**Our Ref: FP/232/12/
Your Ref:**

22nd November 2012

**Town & Country Planning Act 1990 (as amended)
Town and Country Planning (Development Management Procedure) (England) Order 2010 (as amended)
Application for Planning Permission**

Development Ground floor alterations and first floor extension with balcony
Location Felpham Sailing Club 21 Blakes Road Bognor Regis West Sussex

PROPOSED GROUND FLOOR PLAN 1:100

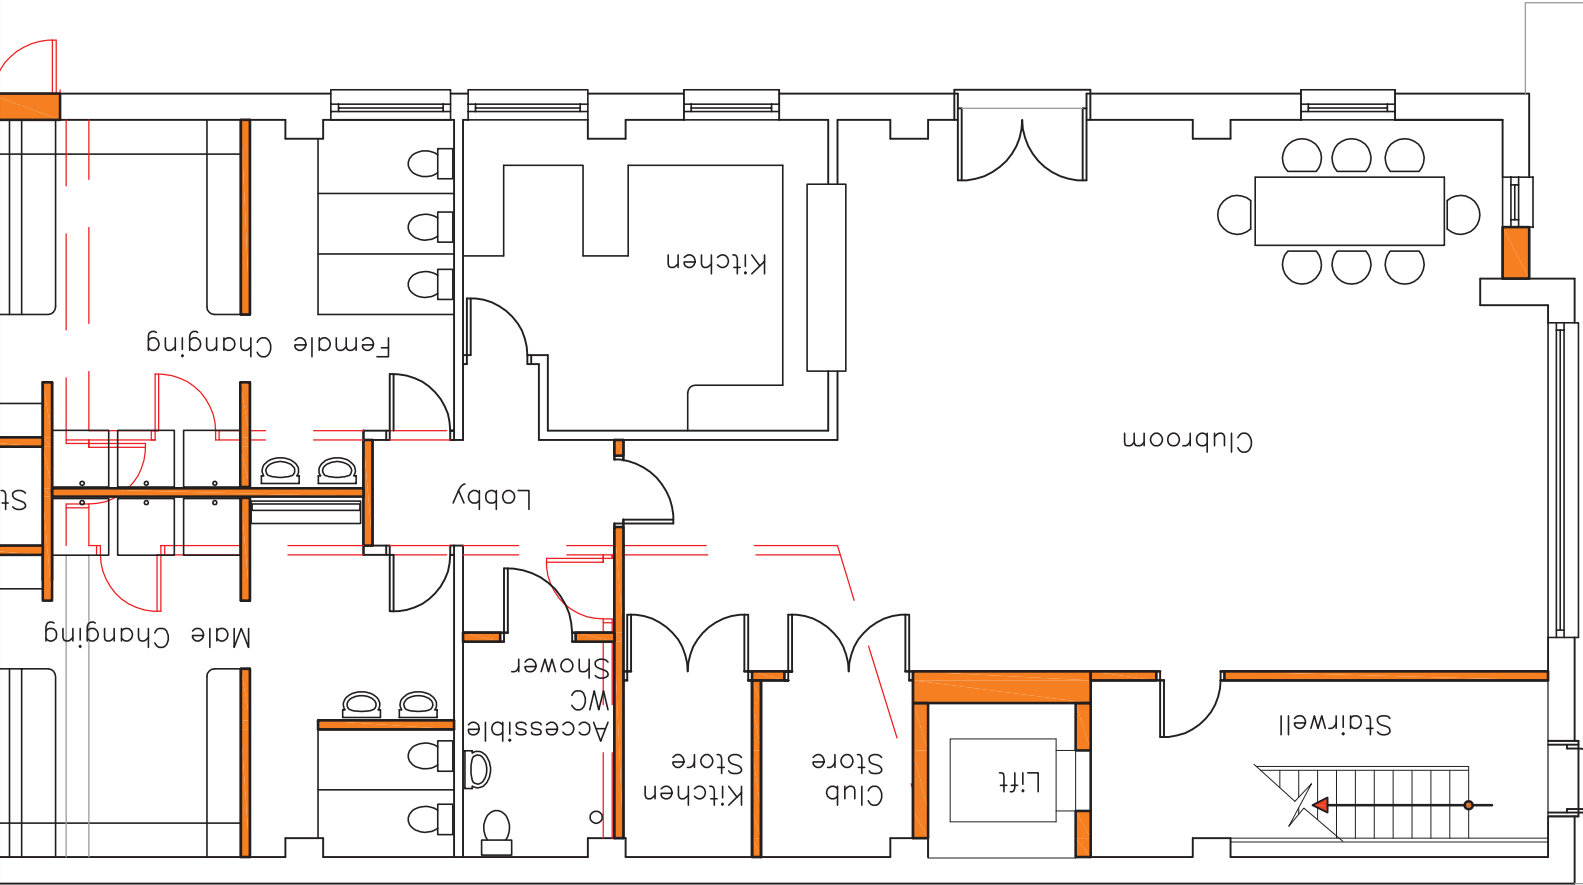
Please forward amended elevation/floor plans. The ground floor south elevation shows a larger window that is shown on the elevation plan. The east elevation (female change & kitchen window) does not measure up correctly.
